(Development Charges Letter)

File No. : CMDA/PP/NHRB/S/1078/2019

Sub: CMDA-Area plans Unit - 'B' Channel (South) – The Planning Permission application received for the proposed construction of Stilt floor + 5 Floors with 8 dwelling units availing Premium FSI of Residential Building at Plot No.7A, D.No.8/16, Srinivasa Avenue Road, Raja Annamalaipuram, Chennai -28. Comprised in Old S.No.4253/2 (Part) as per document and New R.S.No.4253/10 and 75, as per patta Block No.91 of Mylapore Village within the limit of Greater Chennai Corporation- Remittance of DC & Other charges – DC advice Sent - Reg

TERRACE FLOOR PLAN

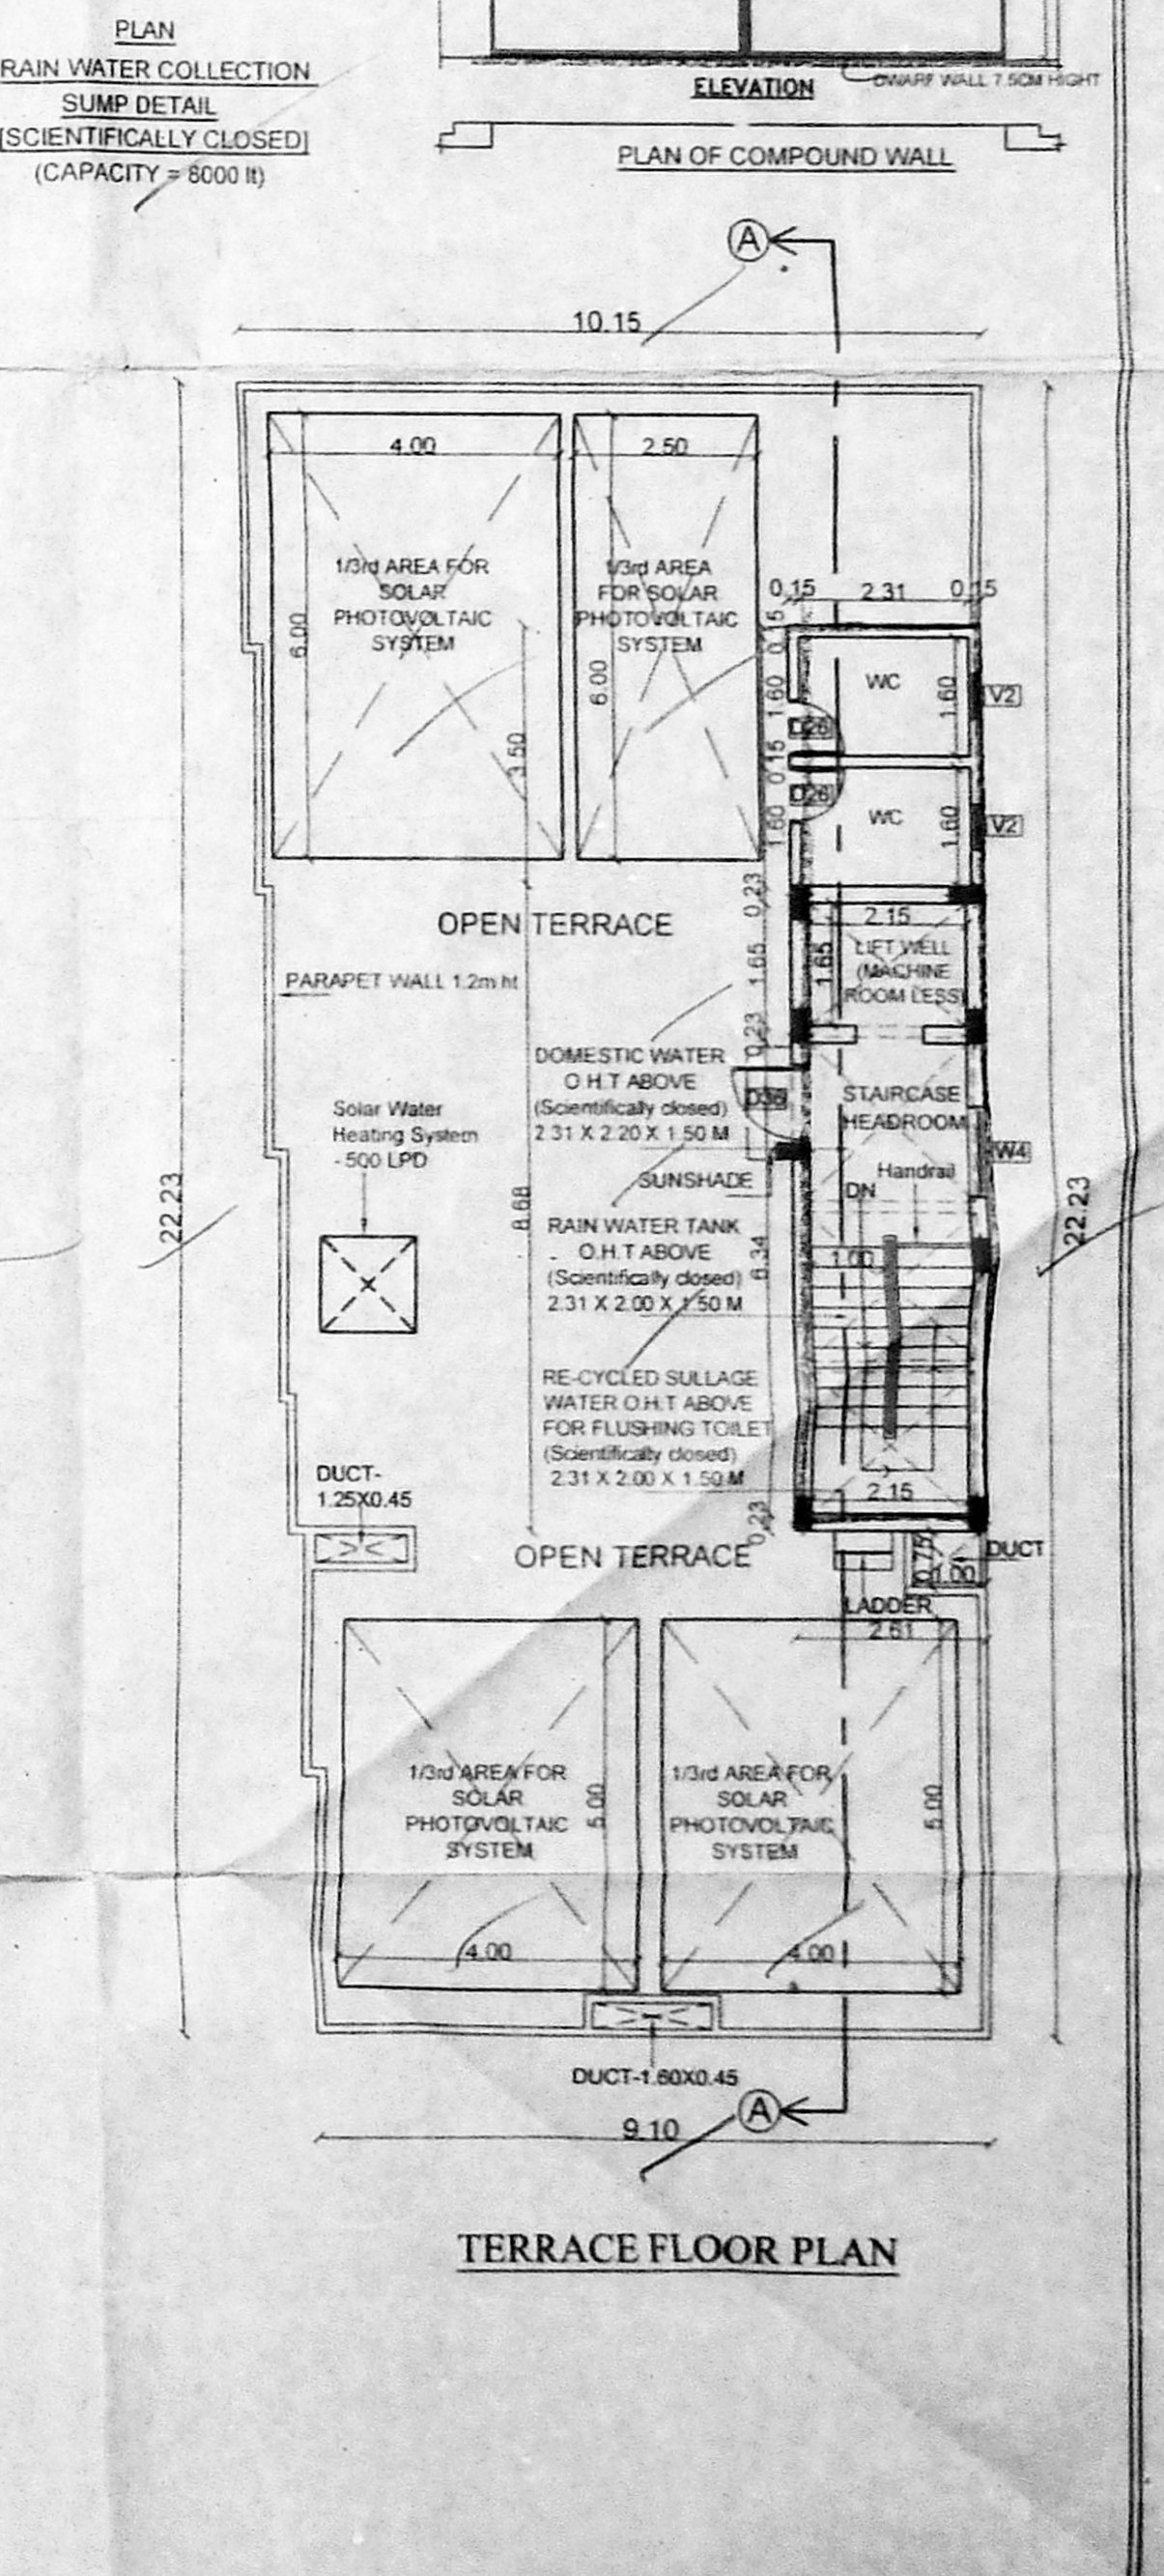
- Area statement and Sections needs correction.
- Head room along with measurement to be shown in the terrace floor plan and breakup measurement to be removed.
